Re: Planning Application No 3/2021/0963 Tanner House Farm Higher Ramsgreave Road, Ramsgreave BB1 9DJ.

#### Planning Application No: 3/2021/0963

Existing Detached Garage Layout Proposed Granny Annex Layout

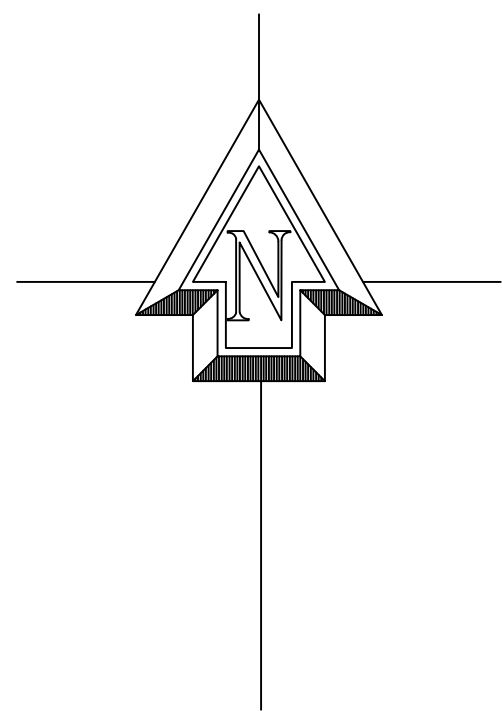
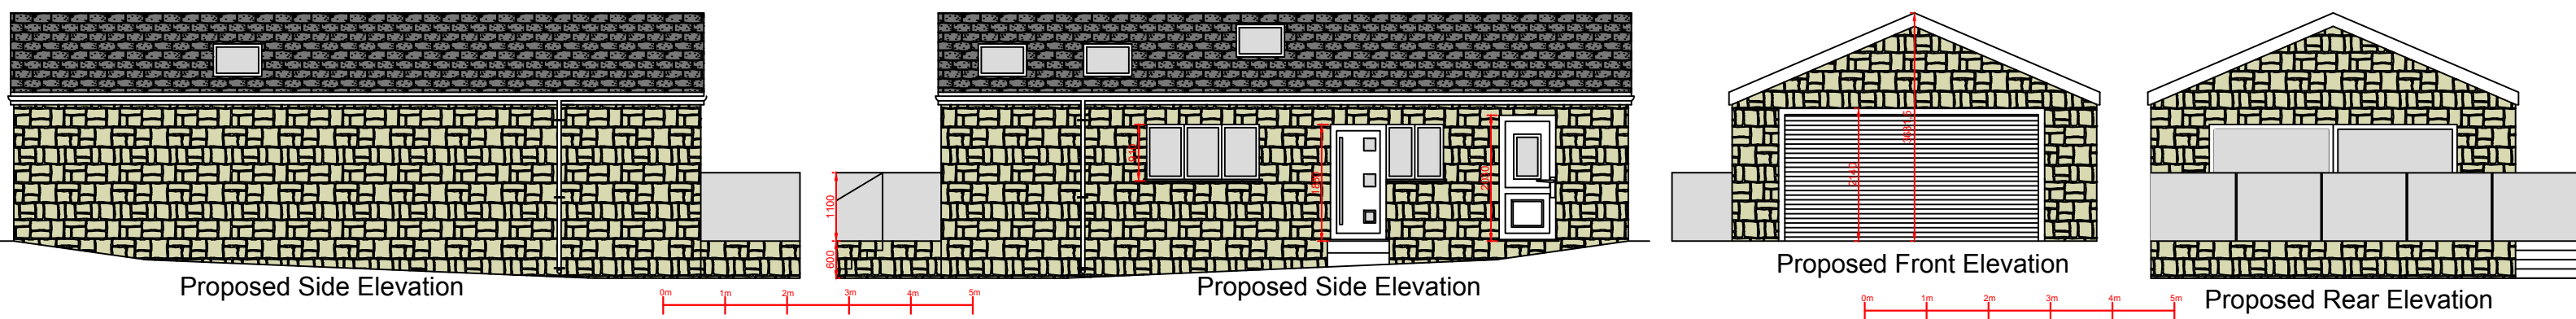
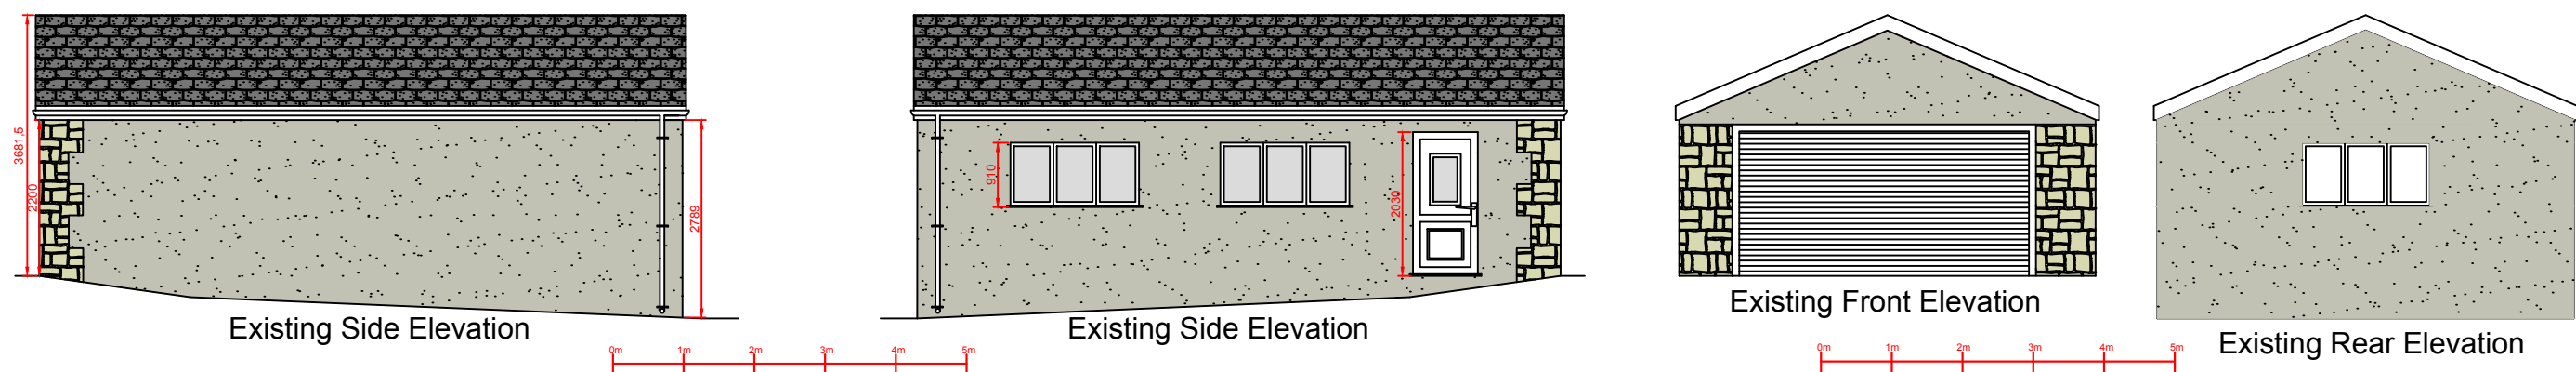
- The overall scale of the extension is overbearing and will dominate the rear aspect of my property, and neighbouring cottages.
- The proposed balcony is potentially compromising
- I can find no detailed information in the plans regarding the conversion of the garage.

The conversion of the garage to a granny annex effectively means that the garage can no longer be used as a garage as it will be too small to fit any car in it. The suggested extension to the garage is too big and the roof windows are unattractive and can be seen from other neighbouring properties. The alterations suggested (both for the house and garage) are not in character with properties in the area and will result in a visual detriment to the surrounding countryside ie it will be partly seen from Higher Ramsgreave Road and Saccary Lane. It will also affect the residential amenity of neighbouring properties ie noise and light nuisance and privacy. Again, there is a further concern about parking should the occupant of the annex possess a vehicle.

Proposed rear extension, conversion and extension to detached garage at :

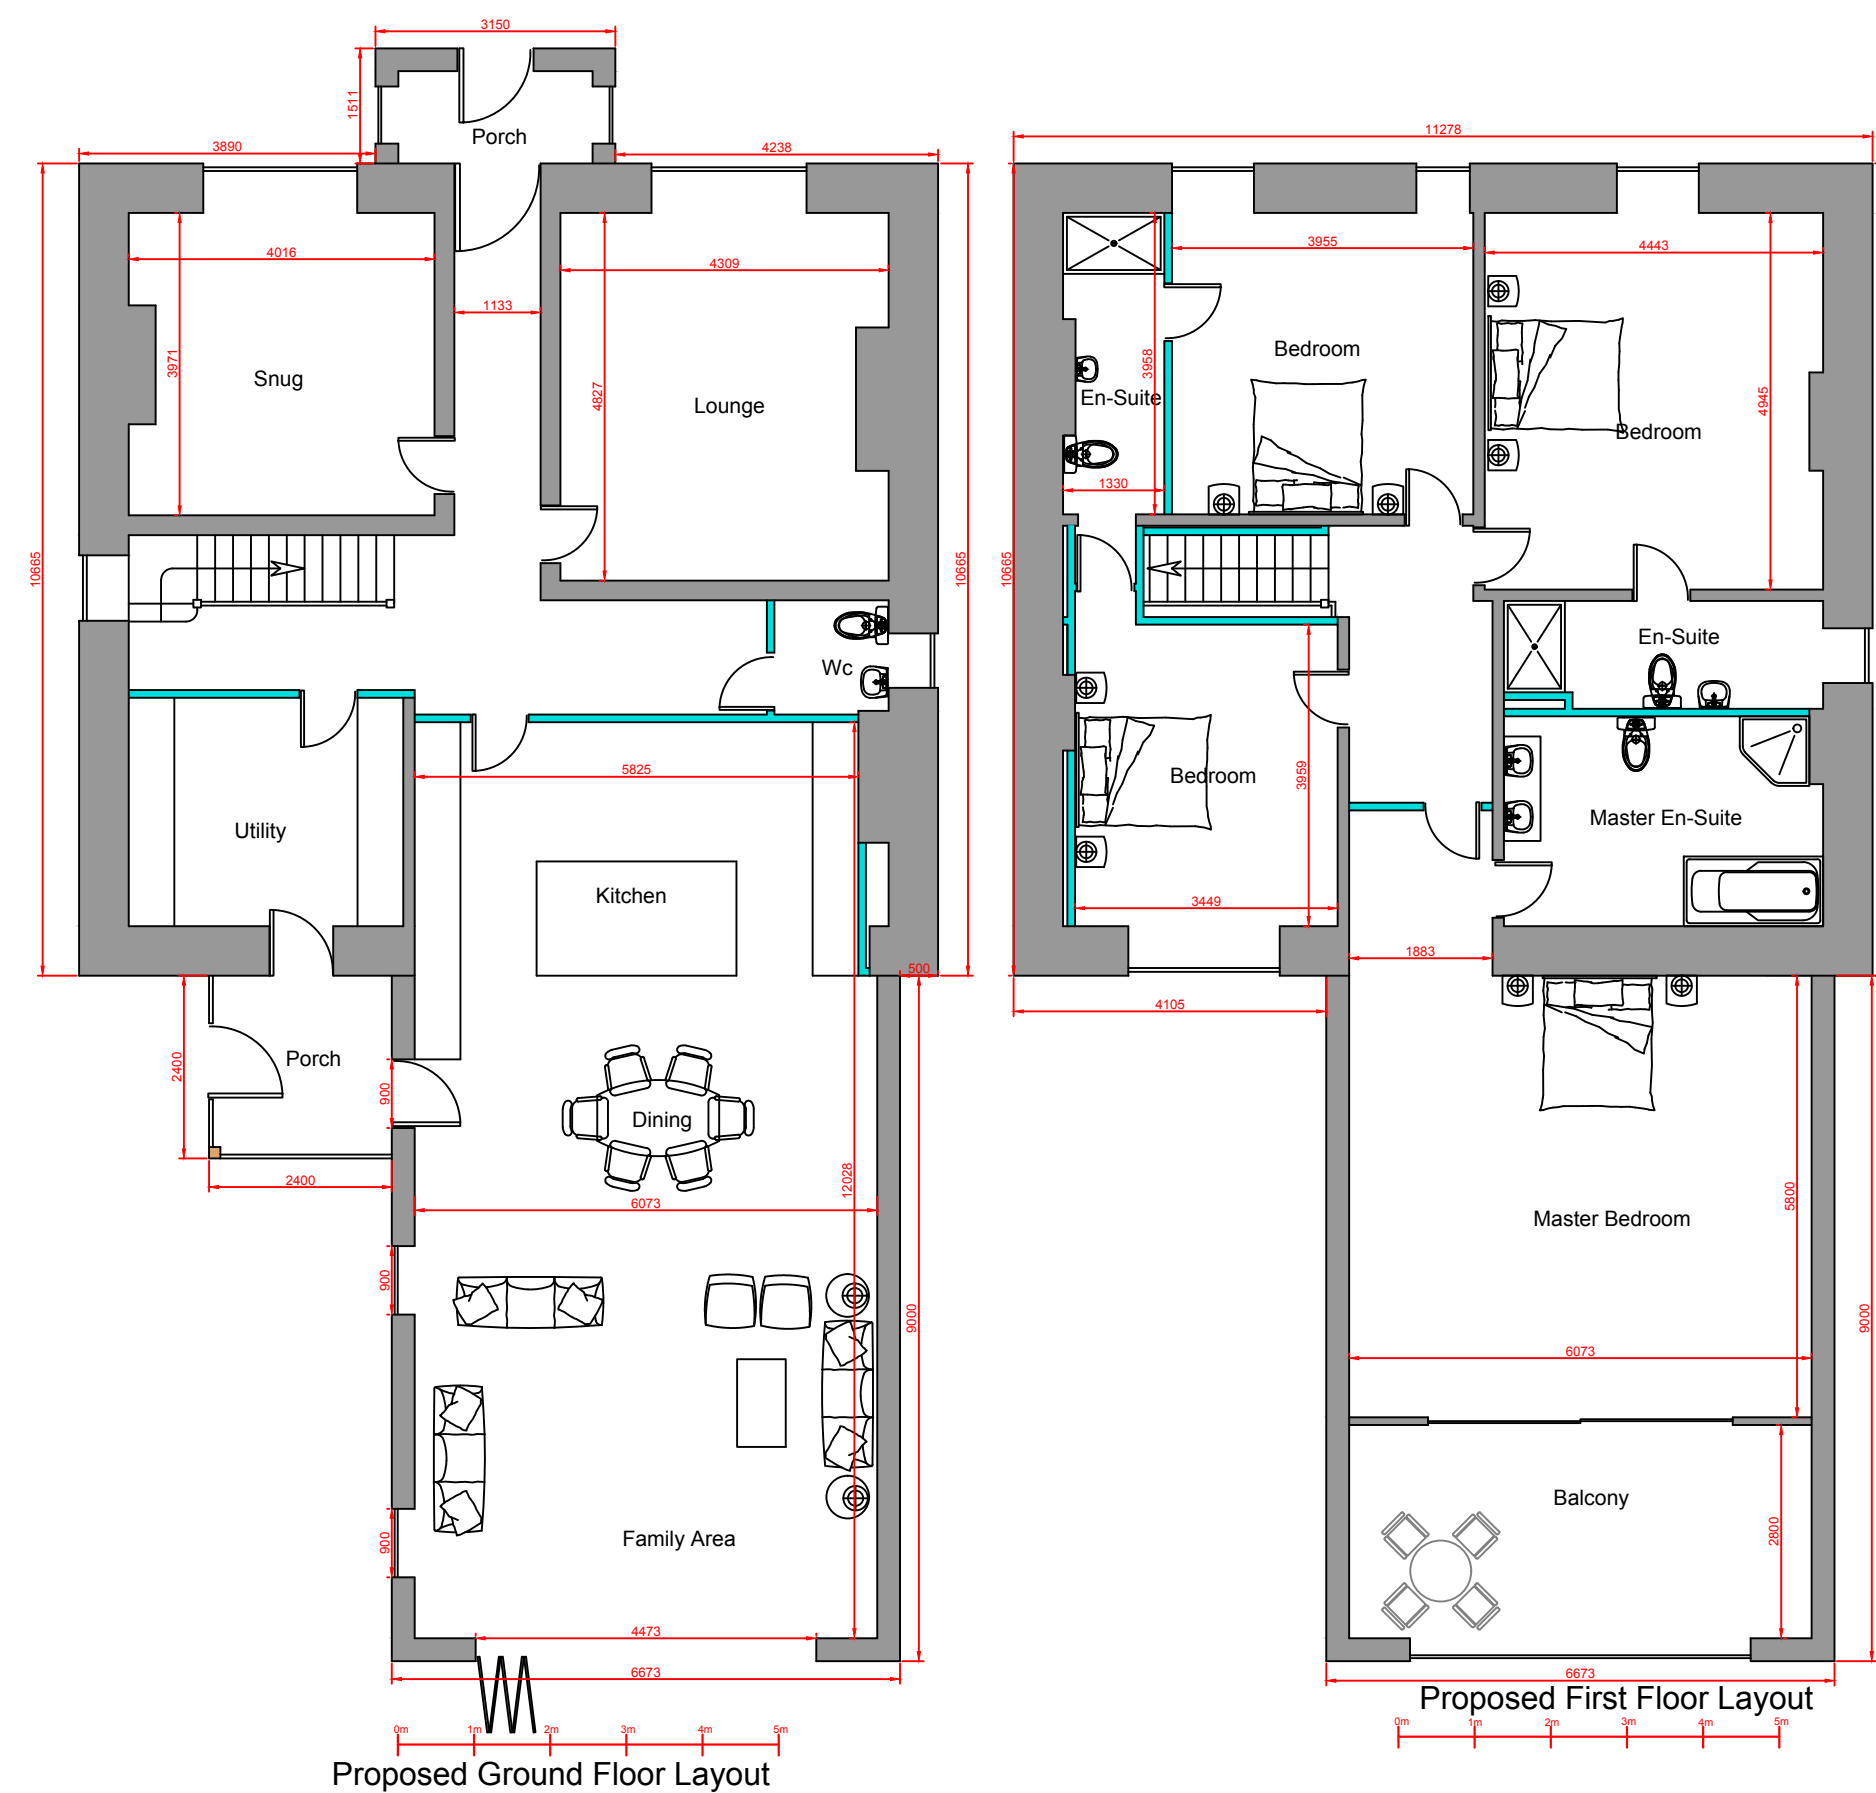
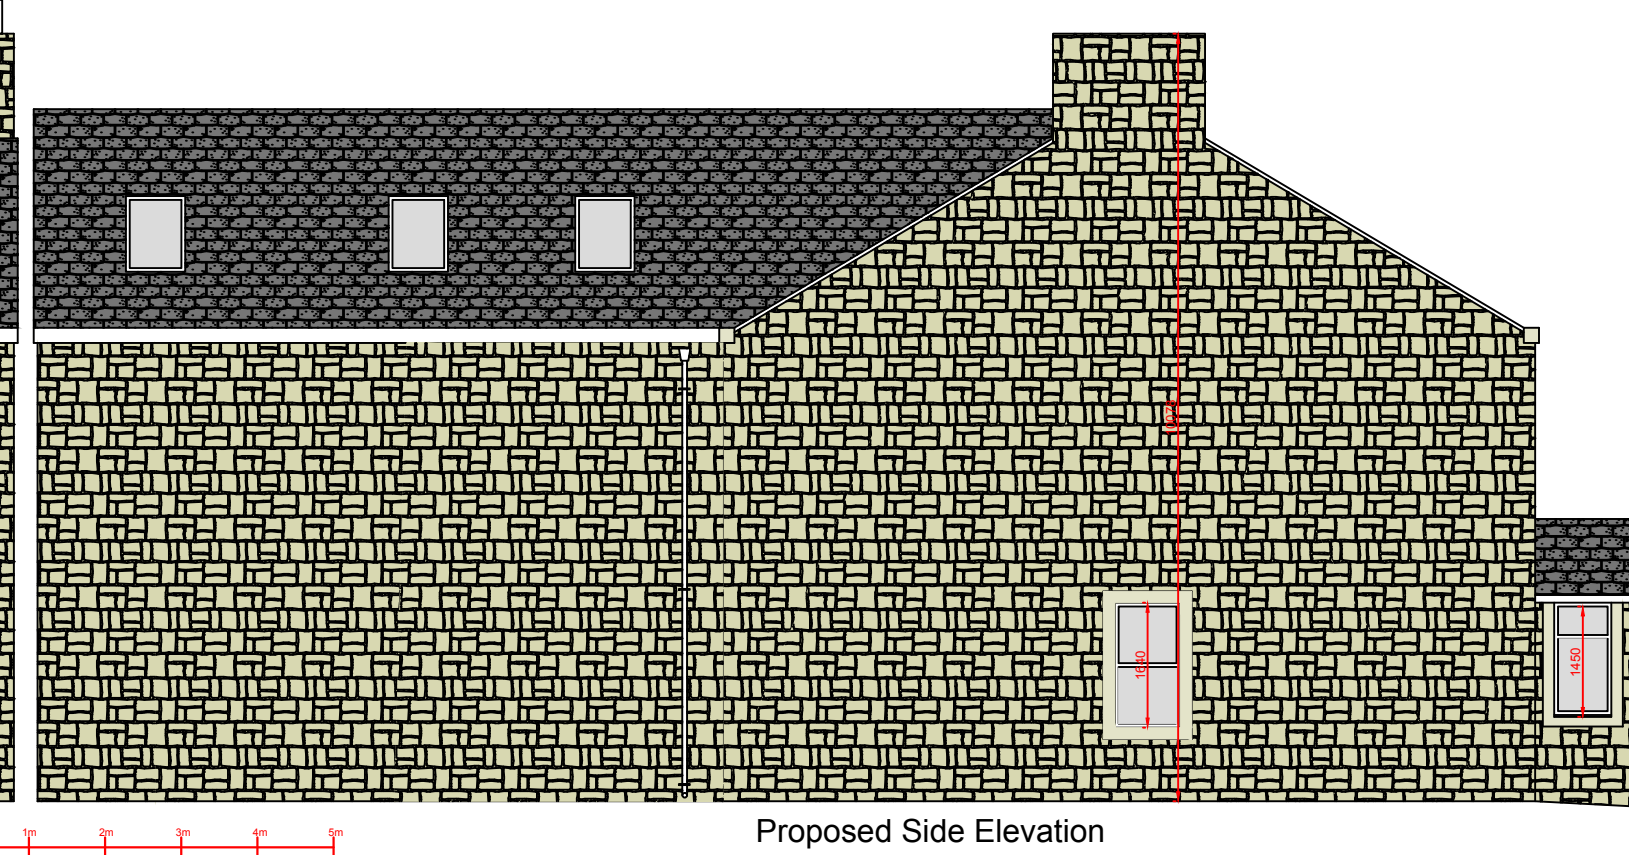
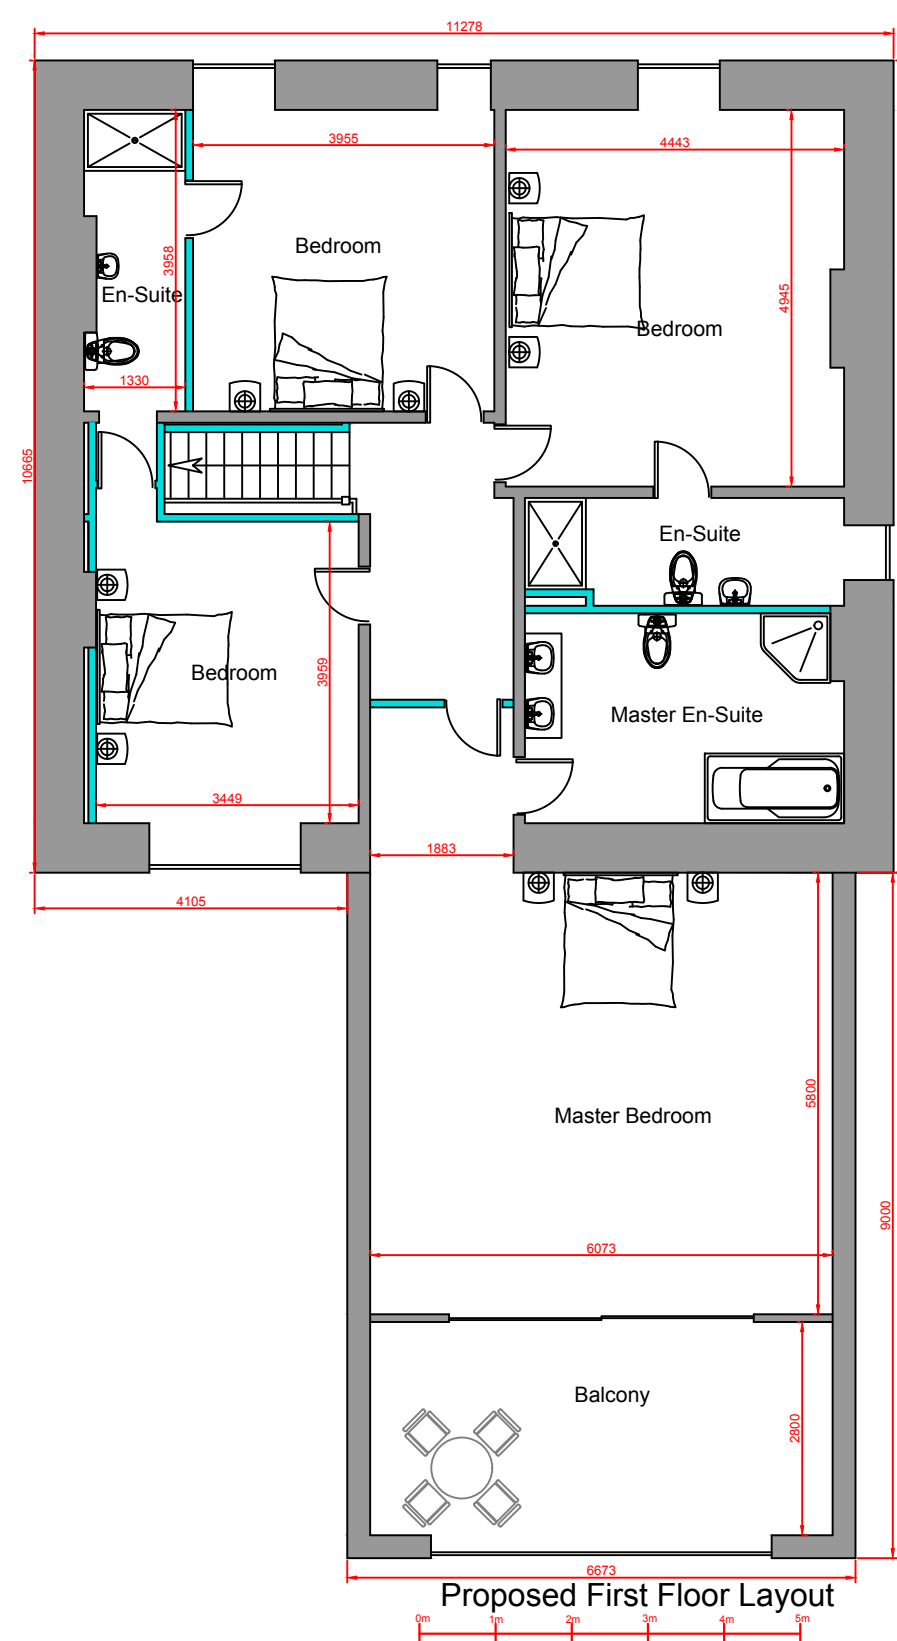
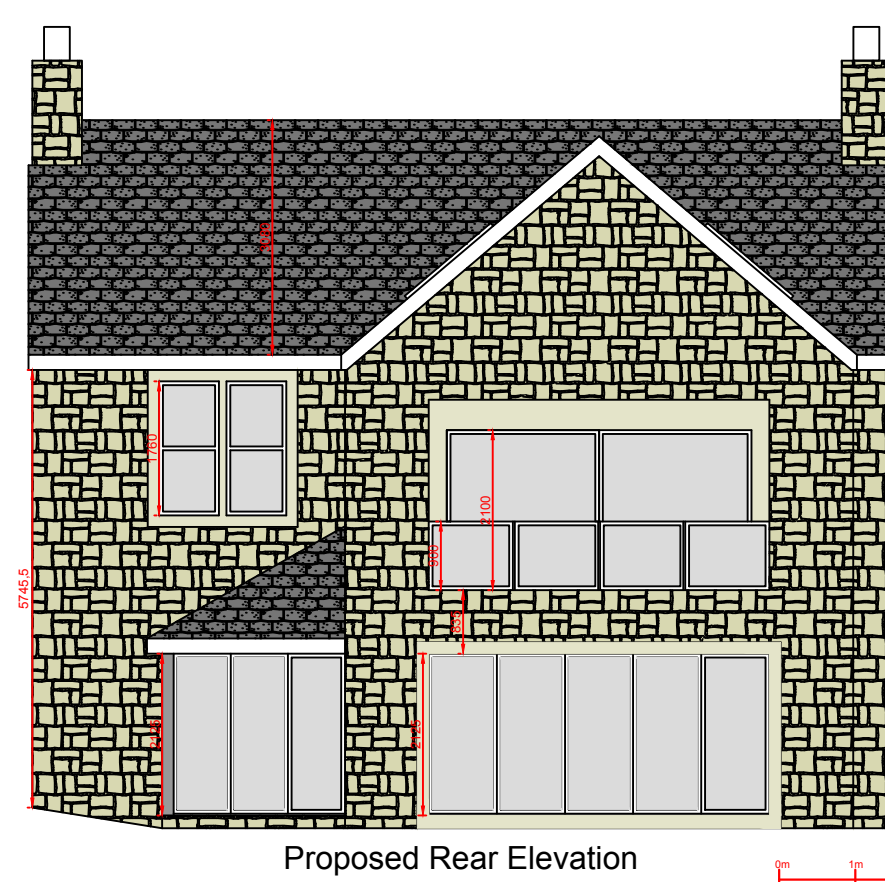
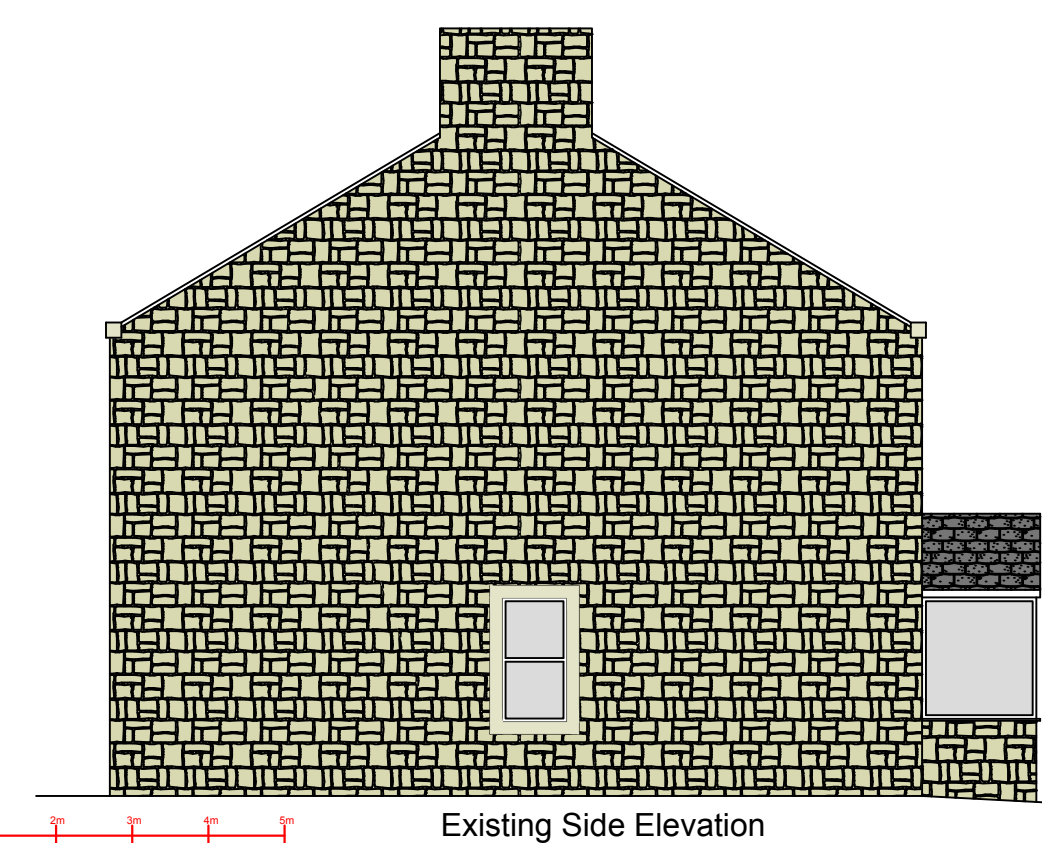
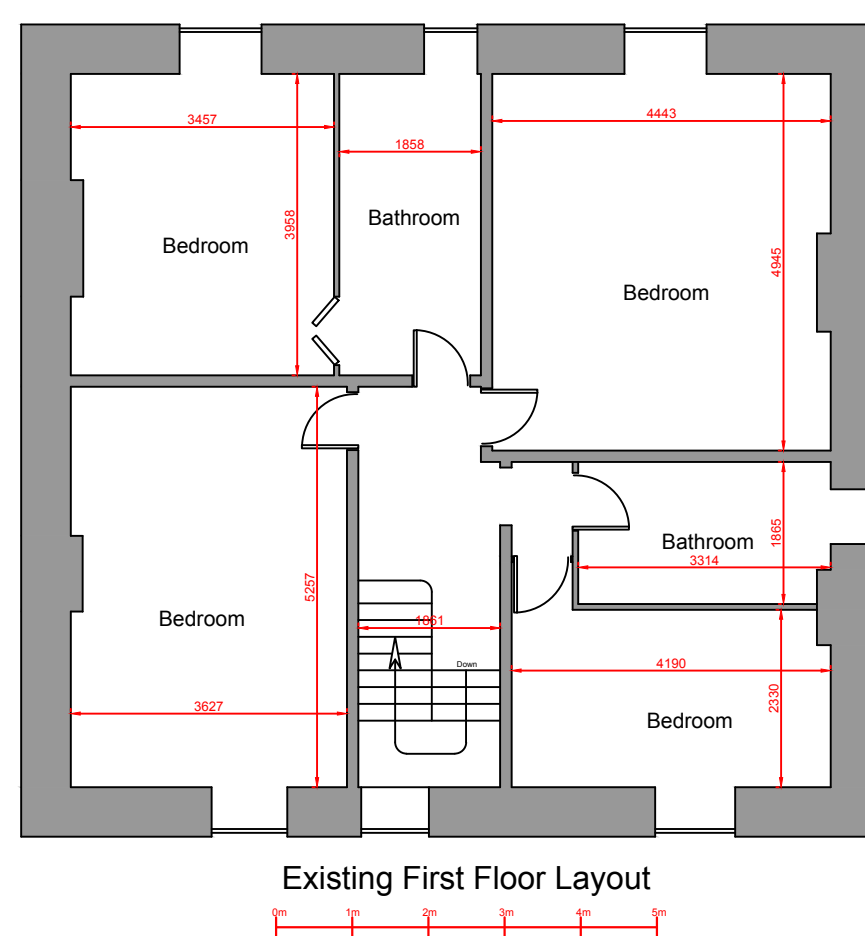
The scale of the rear extension and balcony is such that it will

The proposed 9 metre, double storey extension would essentially be adding another house onto the back of the property and is unsympathetic with the character of the property and area. The scale is far too large for Ribble Valley and will affect the character of the neighbourhood, which has been persevered for many years.

The proposed extension is excessive - it will be almost the size of the existing house and will change the nature of the present building ( ie a farmhouse) and is out of keeping for the area. The roof windows are unattractive and the suggested balcony is overly large and would be intrusive for neighbouring properties and is out of keeping for the present building.
